Wayne R. Dashfield, PE

April 12, 2023

Subject: Existing LVL's
1242 Cool Springs Road
Lillington, North Carolina

2nd Floor Beam

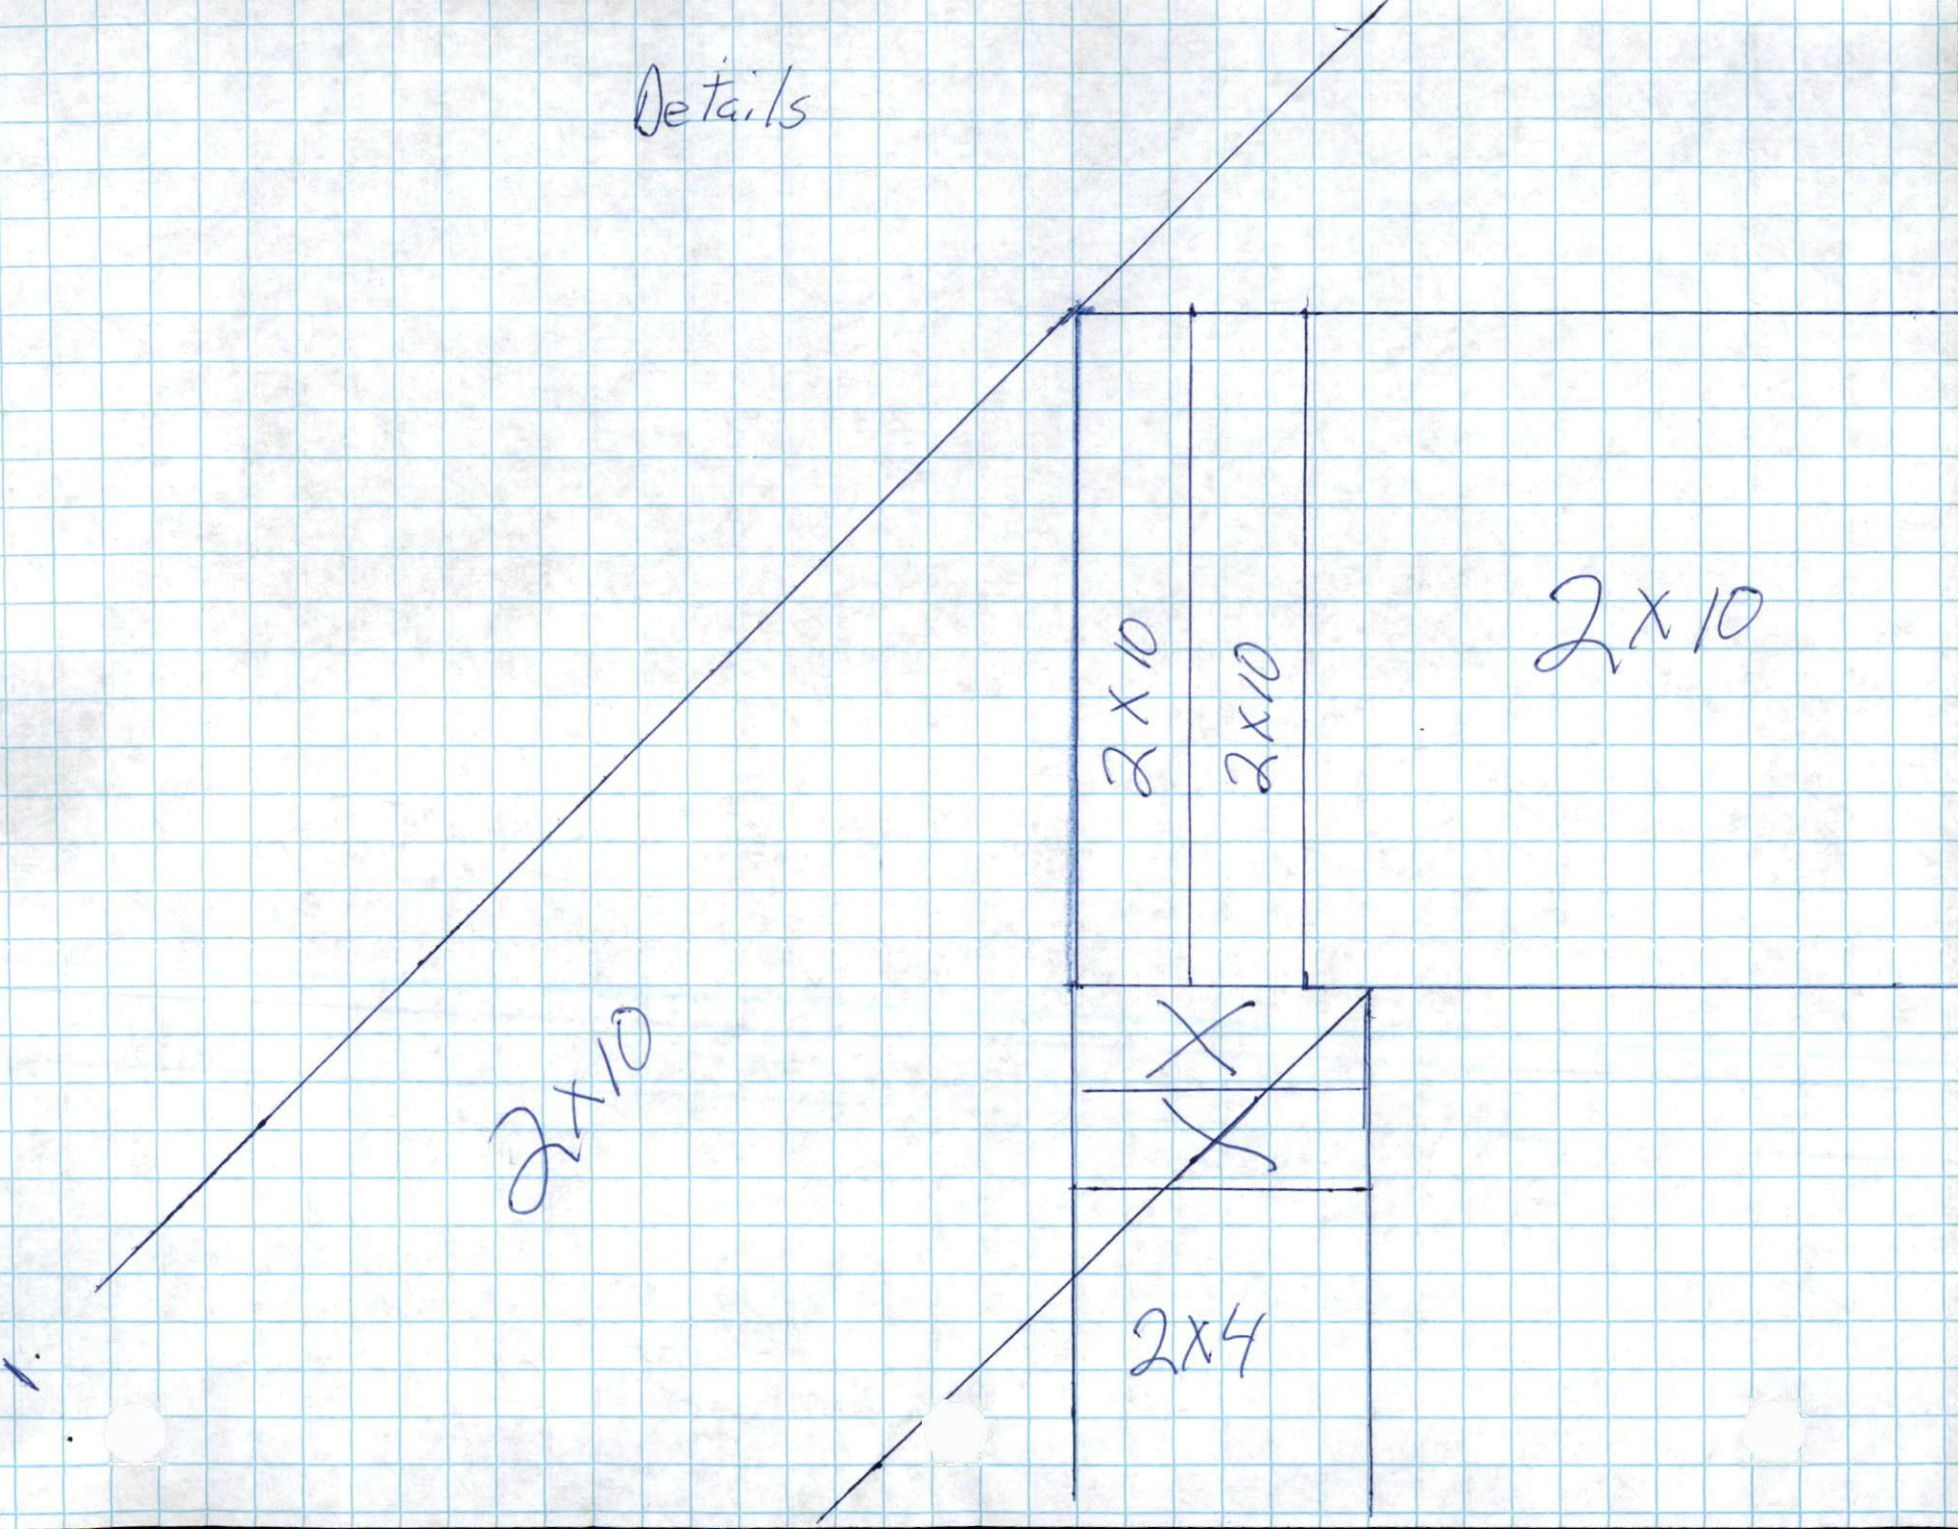
The 8' wide catwalk is supported by a (2) 14" 1.75x2.0e LVL spanning 16' on both sides of the catwalk. The existing catwalk requires LVL's with a bending moment greater than 12,500 ft-lbs. The existing (2) PLY 14" LVL has a bending moment of 27,162 ft-lbs. These LVL's are adequate.

The 8' cat walk is supported by a (2) 2x10 floor joists with a 9.25" 1.75x2.0E LVL on both sides of the cat walk. Listed below is a summary of the loads and size of the LVL and lumber sizes.

Bending moment required = 7680 ft-lbs

Bending moment for (2) #2 PLY 2x10 = 3433 ft-lb

Bending moment for (1) PLY 9.25 LVL = 6208 ft-lb

Total bending moment = 3433+6208=9641 ft-lb OK

In the open basement area the owner has installed four (2) ply 2.0E x1.75x 16" LVL for the first floor support. This loading condition would require a beam capable of a 19,624 ft-lbs bending moment. A (2) PLY 16" LVL can support a loading condition with a bending moment 34,954 ft-lbs. These (2) PLY 16" LVL' are adequate for this support.
